Connah's Quay Low Carbon Power Project; EN010166
Interested Party Ref: ██████████

Natural England's submission for Deadline 7 in respect of the Connah's Quay Low Carbon Power Project, promoted by Uniper.

Annex 1 – Comment on documents submitted at Deadline 6

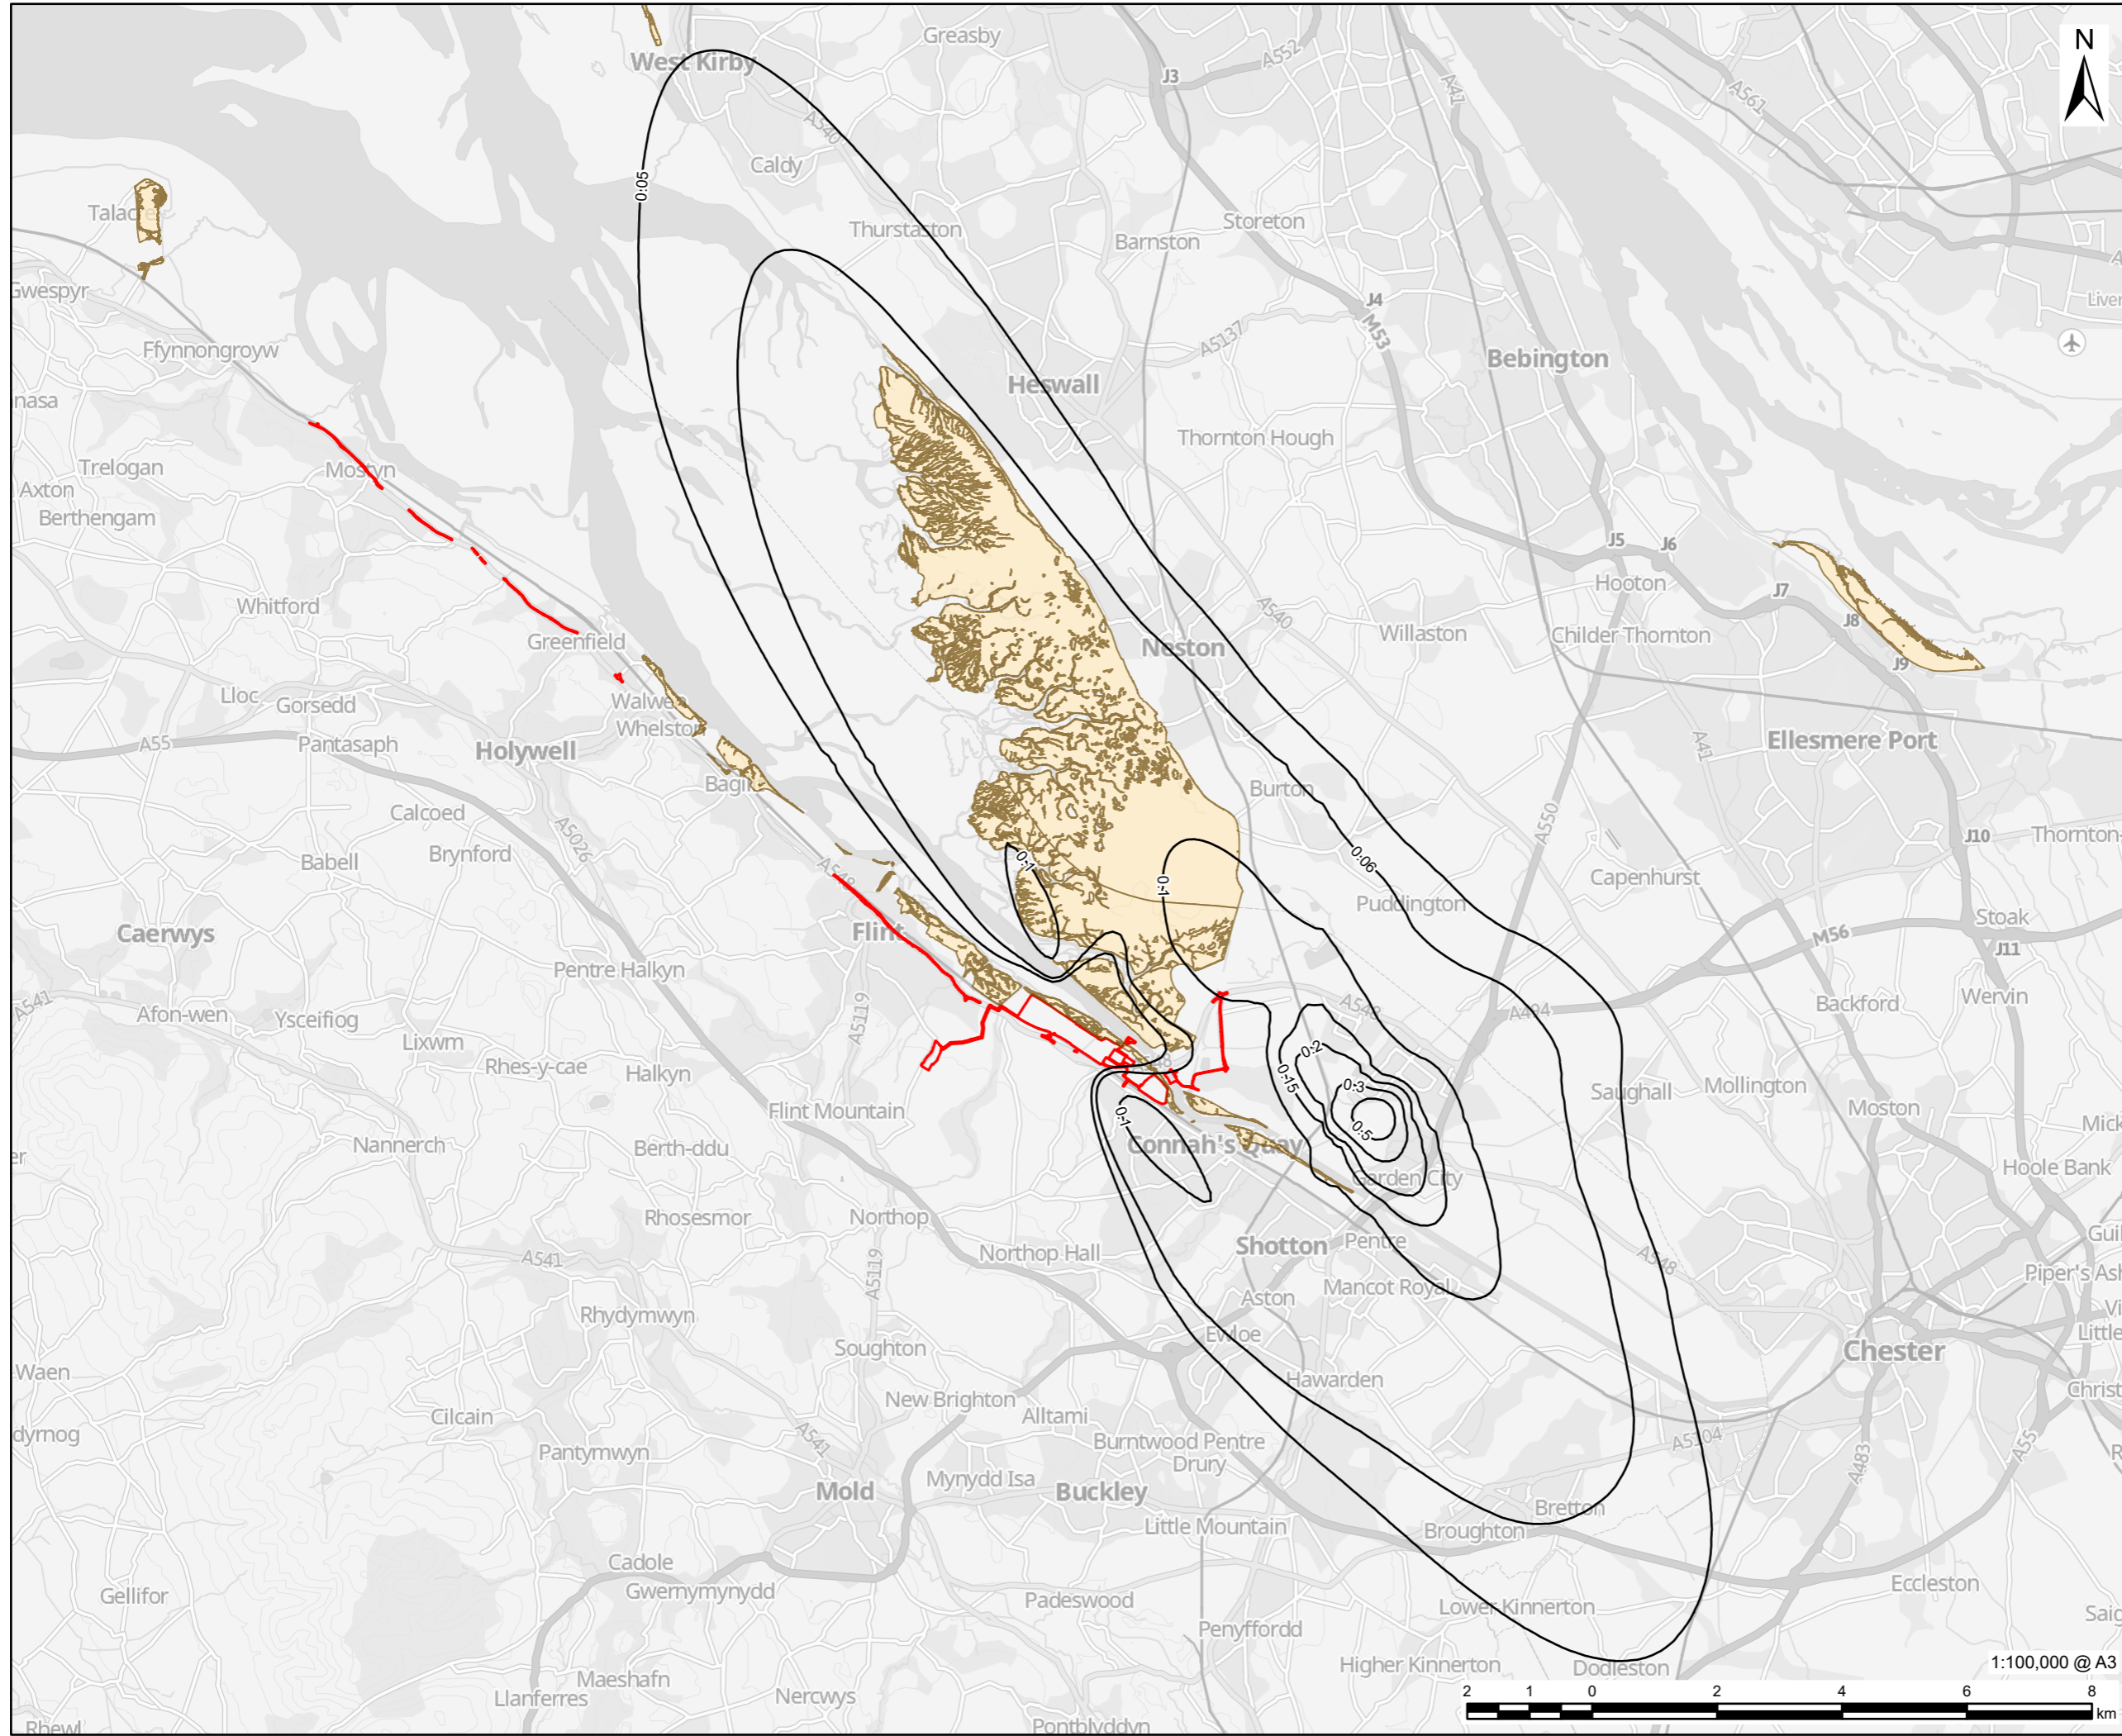
We note the comments made by NRW regarding the discrepancies between the data presented in the updated Plate 2 of the Additional Operational Air Quality Considerations document [REP6-091] which

includes a “FEED 2 Abated Scenario, Nitrogen Deposition Process Contribution” isopleth contour map that contradicts the reported maximum figures in Appendix 8-D: Air Quality Operational Assessment report. We support the advice given by NRW that clarification should be sought as to why the isopleth contour plot does not show equivalent values as those presented in the Air Quality Operational Assessment tables.
